From: [Barry Hanson](#)
To: [Jamey Ayling](#); [CDS User](#)
Subject: Public Comments on CU-23-00003 Fowler Creek Guest Ranch
Date: Thursday, October 19, 2023 10:29:53 AM

Re: Fowler Creek Guest Ranch (CU-23-00003)

I am submitting this notice of opposition to highlight the lack of specifics on the sewage treatment plan.

SEWAGE MANAGMENT SITE PLAN MAP - FOWLER CREEK GUEST RANCH

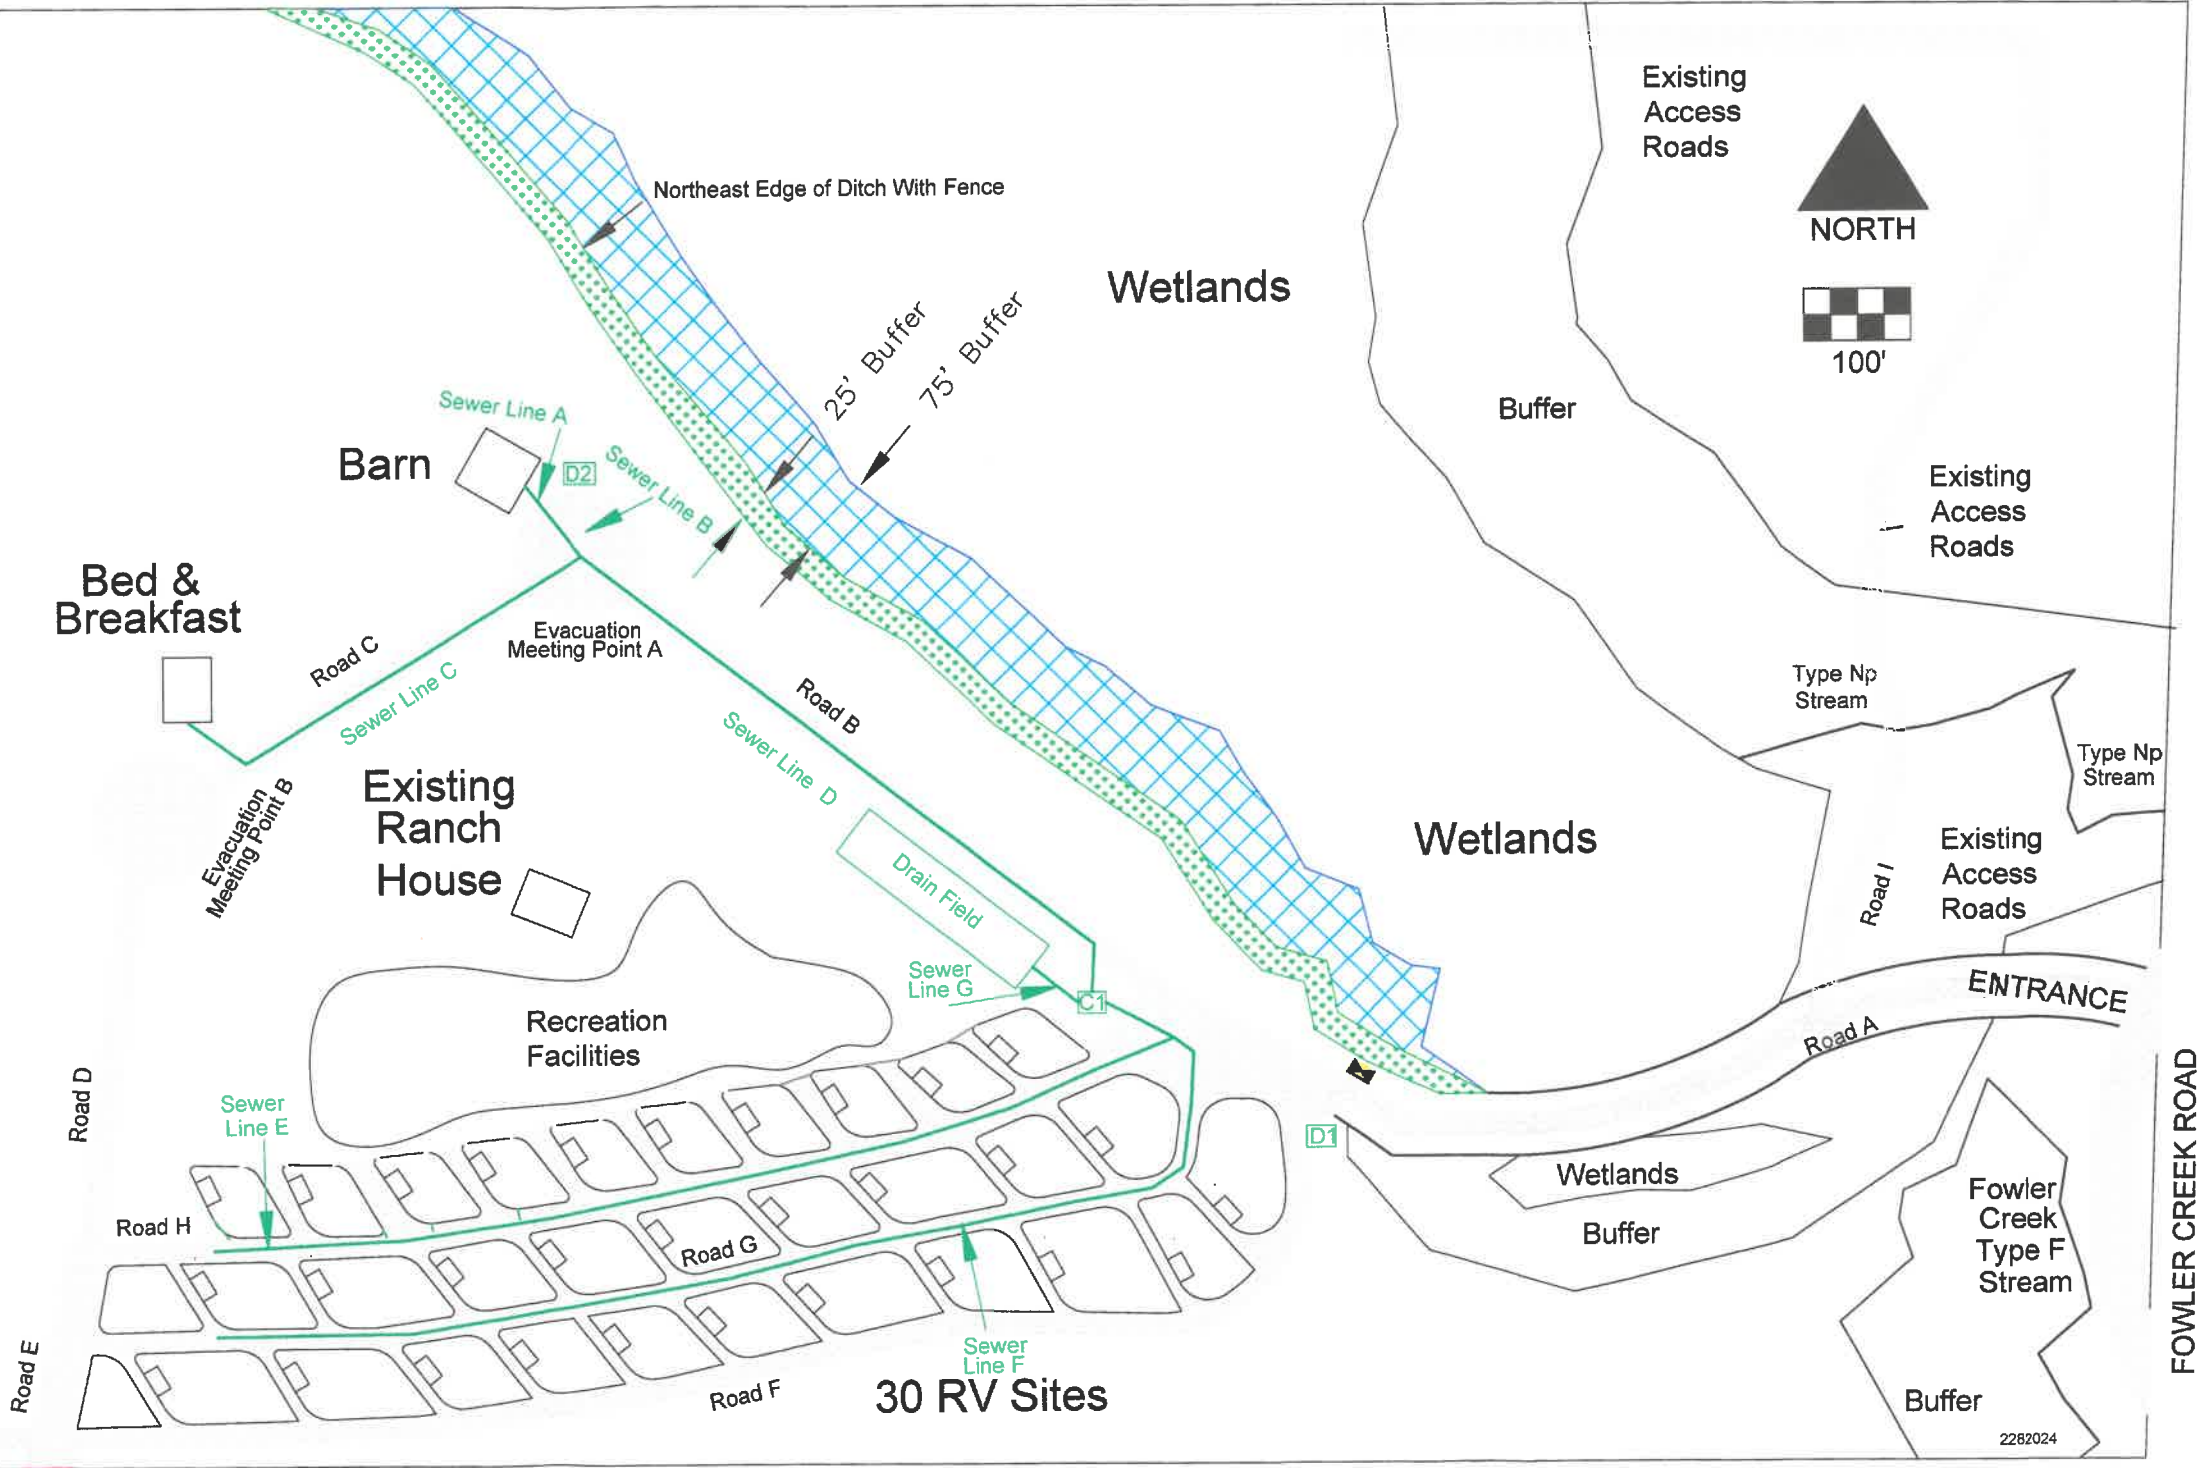
I'm concerned that with 2 wetland areas and 2 streams that the plan needs to have a lot more detail. With the potential for 6620 gallons per day of drainage seeping into the ground, knowing specifically where the drain fields would be located is critical. How far away from the wetlands or streams do you have to be with a drainfield to ensure no contamination? Is it even possible to locate drain fields on the proposed site and be far enough away from the wetlands to ensure no contamination?
